# Drainage Report Redlines.pdf Markup Summary

STORM SCHEMATIC

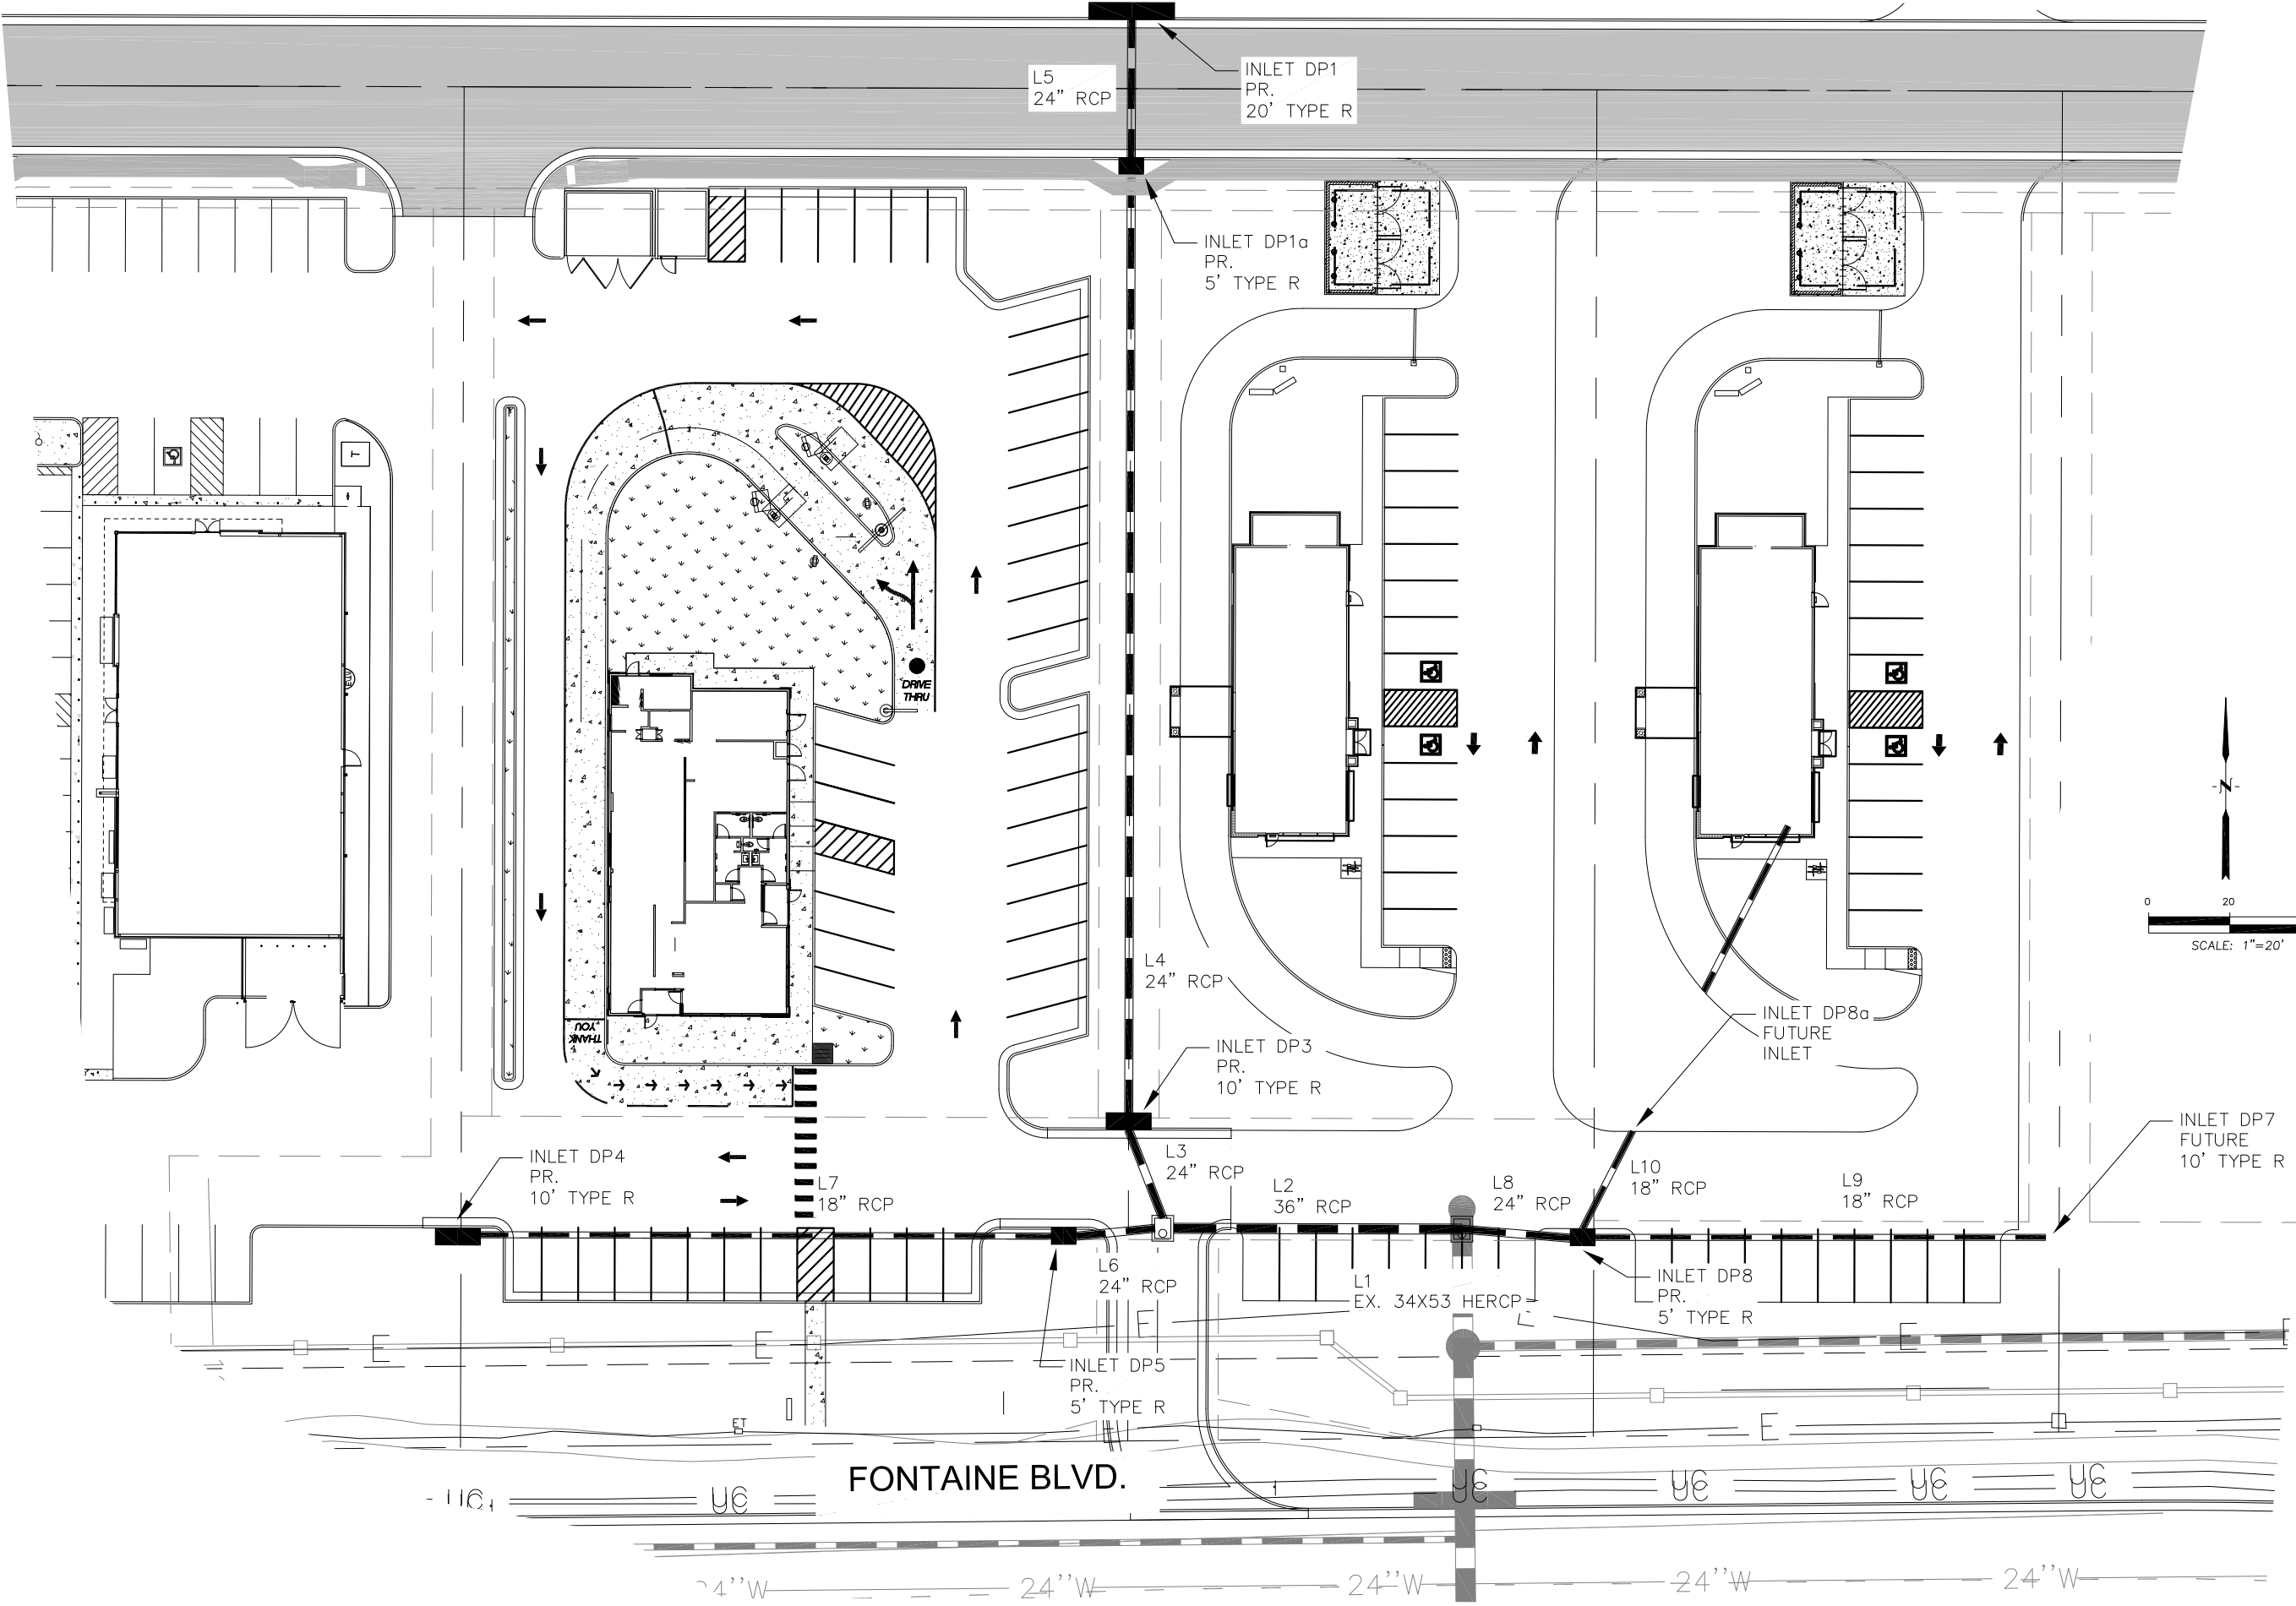
Per note below, HGL is above crown. Revise design to be in pipe or add note to plans.

Provide velocities for each pipe in system for 5 & 100 designs.

NOTE ADDED TO PLAN.

VELOCITIES ADDED.

- PLAT BOUNDARY
- BASIN BOUNDARY
- BASIN DESIGN POINT
- BASIN I.D.
- ACREAGE
- 5 YR/100 YR CFS
- DIRECTION OF FLOW
- EXISTING CONTOUR
- PROPOSED CONTOUR
- ROW/LORSON RANCH BOUNDARY
- EXISTING STORM SEWER
- PROPOSED STORM SEWER
- TIME OF CONCENTRATION
- HIGH POINT
- LOW POINT
- CROSSSPAN (6' OR 8')

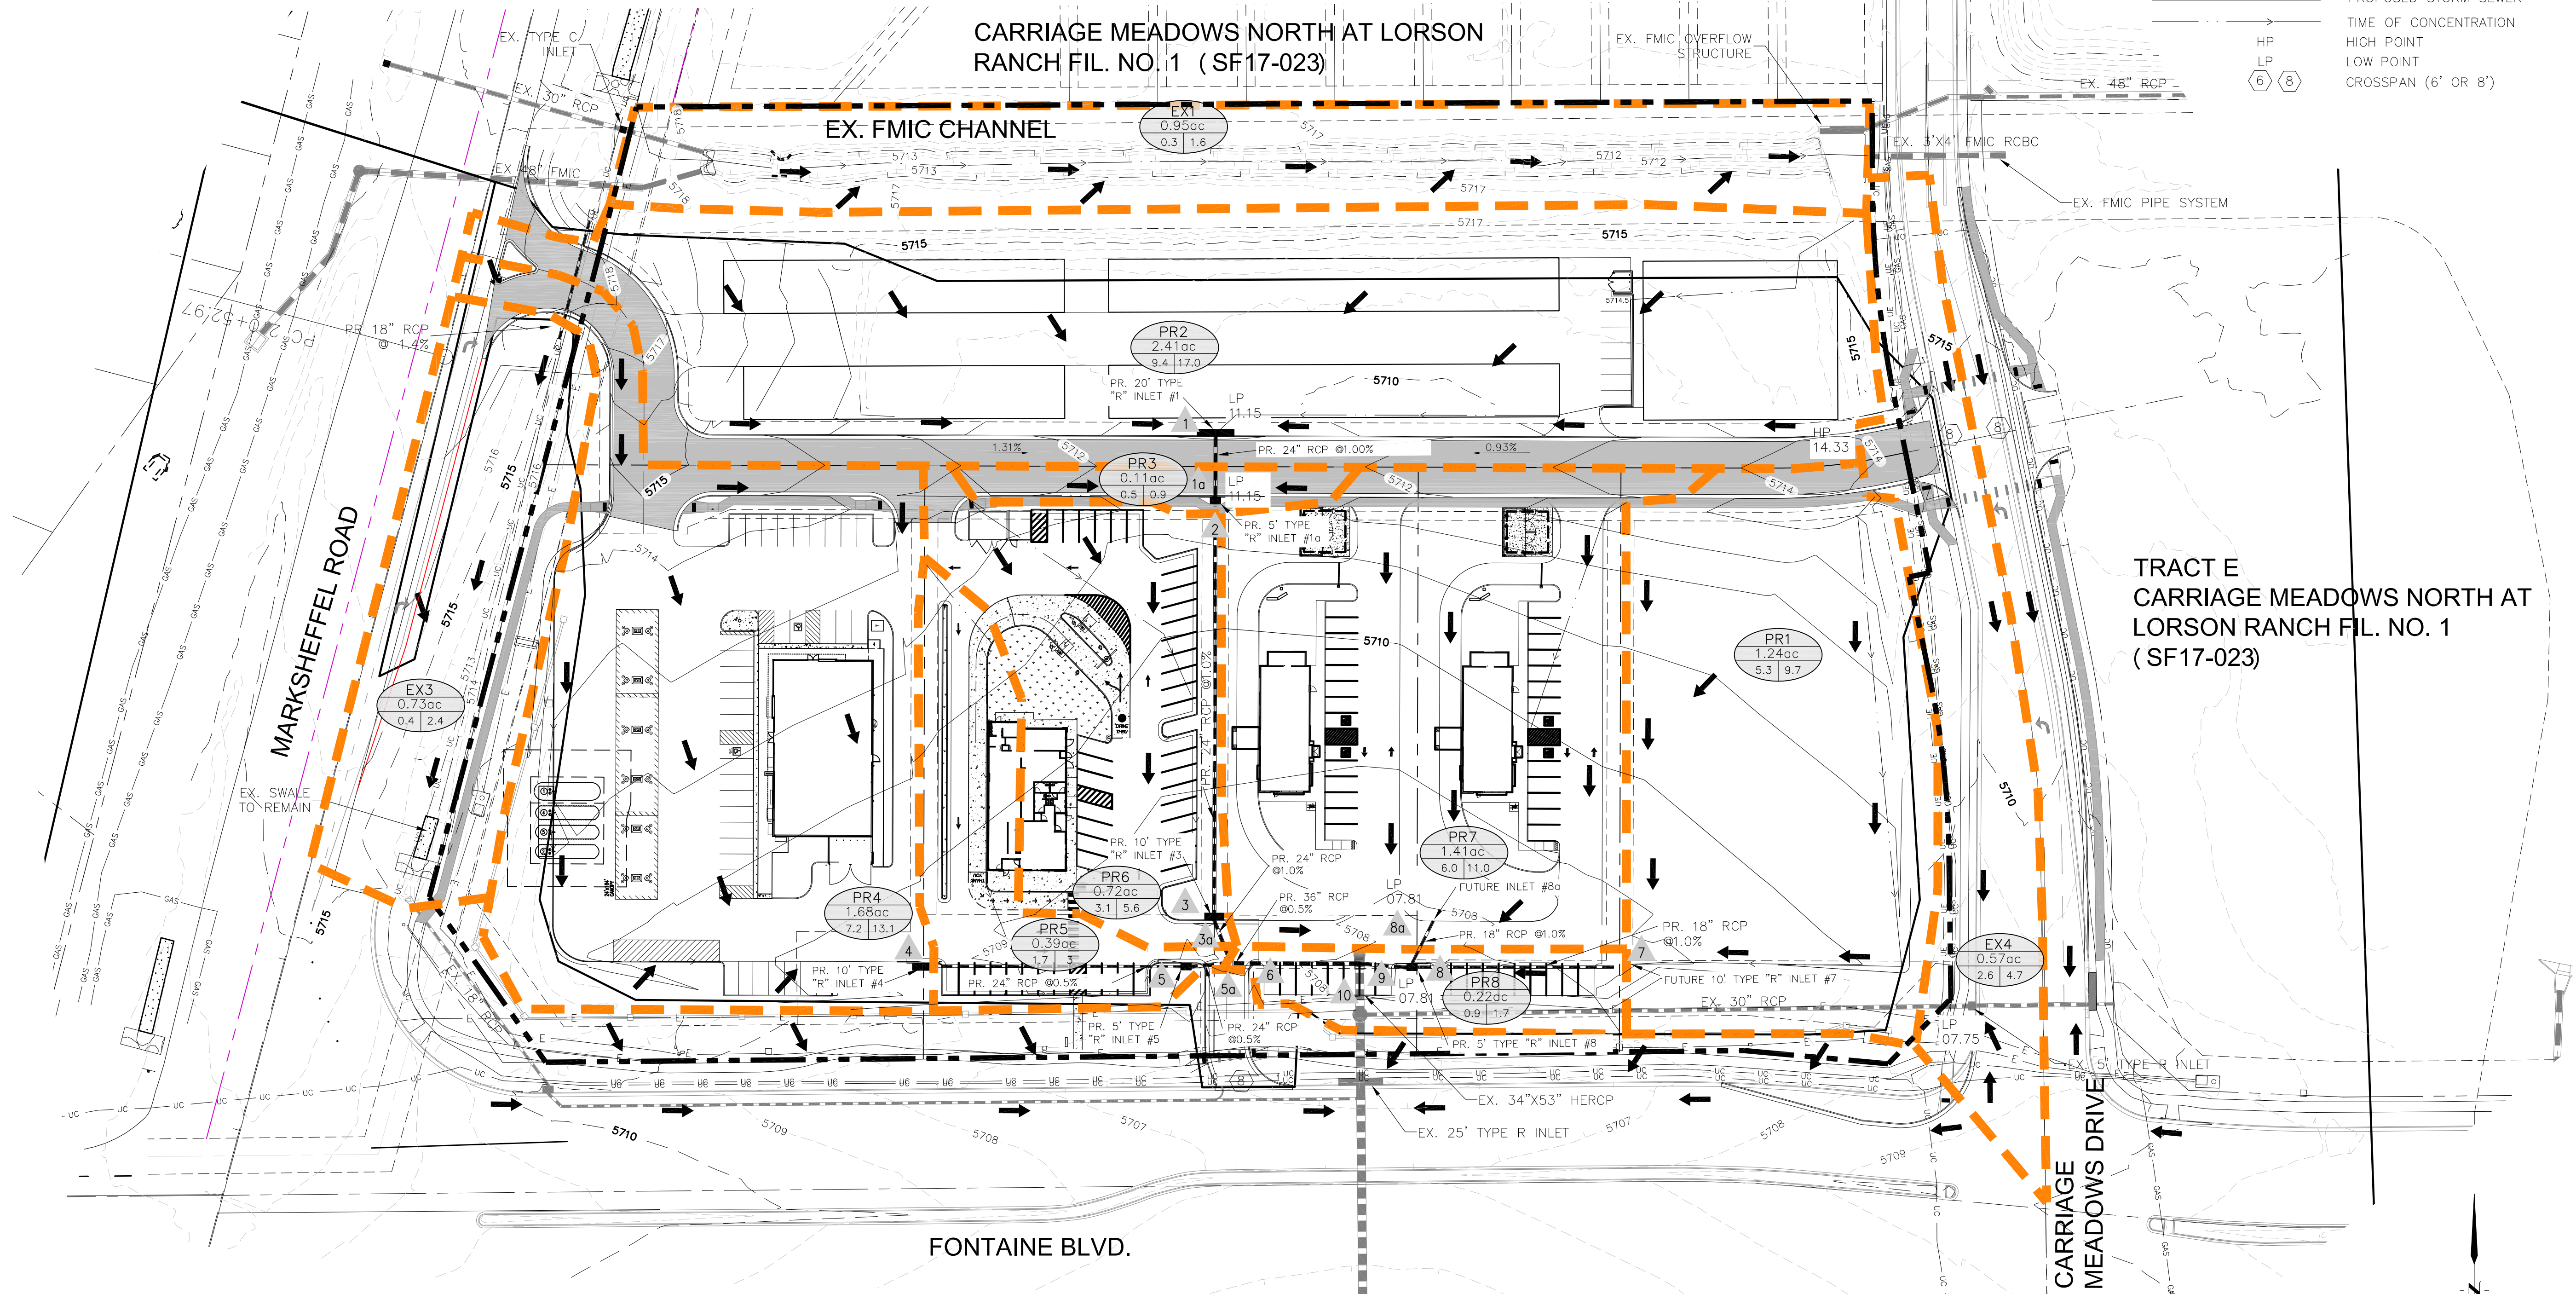
Label what flows are entering site from these sets of pipes.

Label streets

Existing pond?

Indicate that this includes bypass flows from DP4 since it doesn't match with DP5 flows on hydrology spreadsheet

Label what flows are entering site from these sets of pipes.

Include road classifications

18" per storm drain calculations

Label c&g type

Per STD SD\_2-26 pan width at arterial is 10'

NO FLOW FROM FMIC ENTERS THIS SITE BUT FLOWS DIRECTLY TO JCC.

ADDED

IRRIGATION POND LABELED

NOTE ADDED

NO FMIC FLOWS ENTER THIS SITE.

ADDED

TEXT IS 18"

ADDED

AN 8' PAN ALREADY LOOKS TOO LARGE.  
 ESPECIALLY ON A RIGHT IN.
